From: Robert Clark [REDACTED]
Sent: 15 May 2019 11:11
To: Laura Gibbons
Subject: RE: Apple Barn Cottage - CM/5/19/HH

From: Laura Gibbons [REDACTED]
Sent: 15 May 2019 10:10
To: [REDACTED]
Subject: RE: Apple Barn Cottage - CM/5/19/HH

From: Robert Clark [REDACTED]
Sent: 27 April 2019 18:11
To: Laura Gibbons
Cc: 'Emma Weaver'
Subject: Apple Barn Cottage - CM/5/19/HH

Project			
Apple Barn Cottage			
A259			
Climping			
Client			
Alex Stephens			
Drawing Title			
Surface Water Drainage			
© This drawing is copyright. It may not be copied or reproduced without written authority.			
Scale	As shown	At original	A3
Drawing Number	2017/SK4	Revision	-

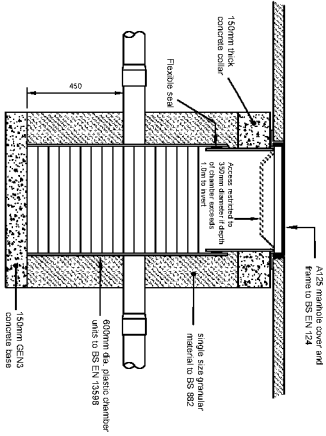
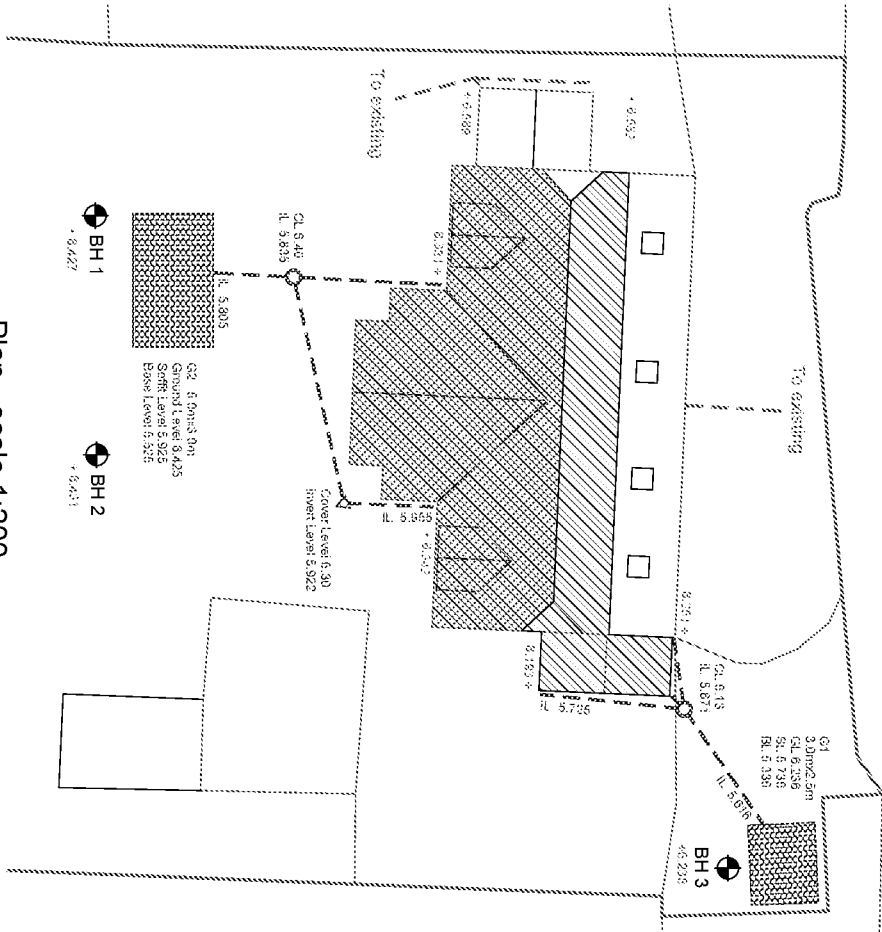
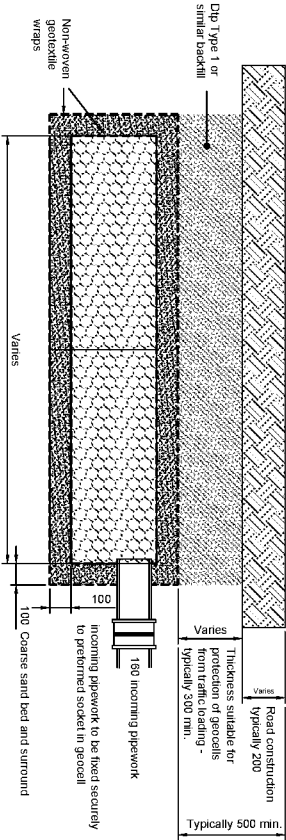
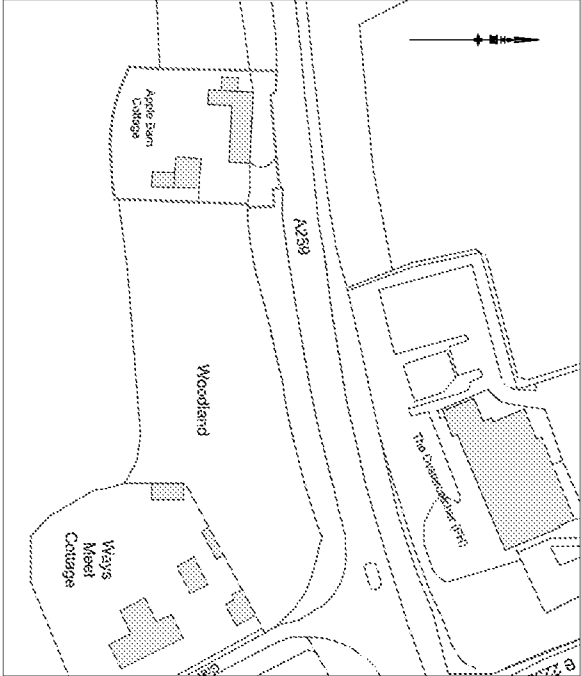
Thanks for sending through the calculations. There is insufficient volume within G2 for the 1 in 100 year +40% climate change. You have an available volume of 5.7m^3 , and the volume of water modelled is 6.6m^3 . Can the soakaway be increased in size so that it is able to accommodate this volume?

You will see that we have now used the perc rate from BH3 to design G1 and it is fine.

We have used the perc rate from BH2 at 929 to design G2 and again it complies, in that there is no surcharge with a 10-year storm and no flooding on a 100-year storm + 40% climate change, so I hope all is ok.

That is fine if there is adequate capacity within the rest of the network.

I feel that you should rely on the MicroDrainage calcs as this is industry standard and shows no flooding on a 100 year storm + climate change.

However, we have 5.7 cu.m storage in the geocell and a further 1.4 cu.m storage in pipework, manholes and the geocell surround, so hope this is ok.
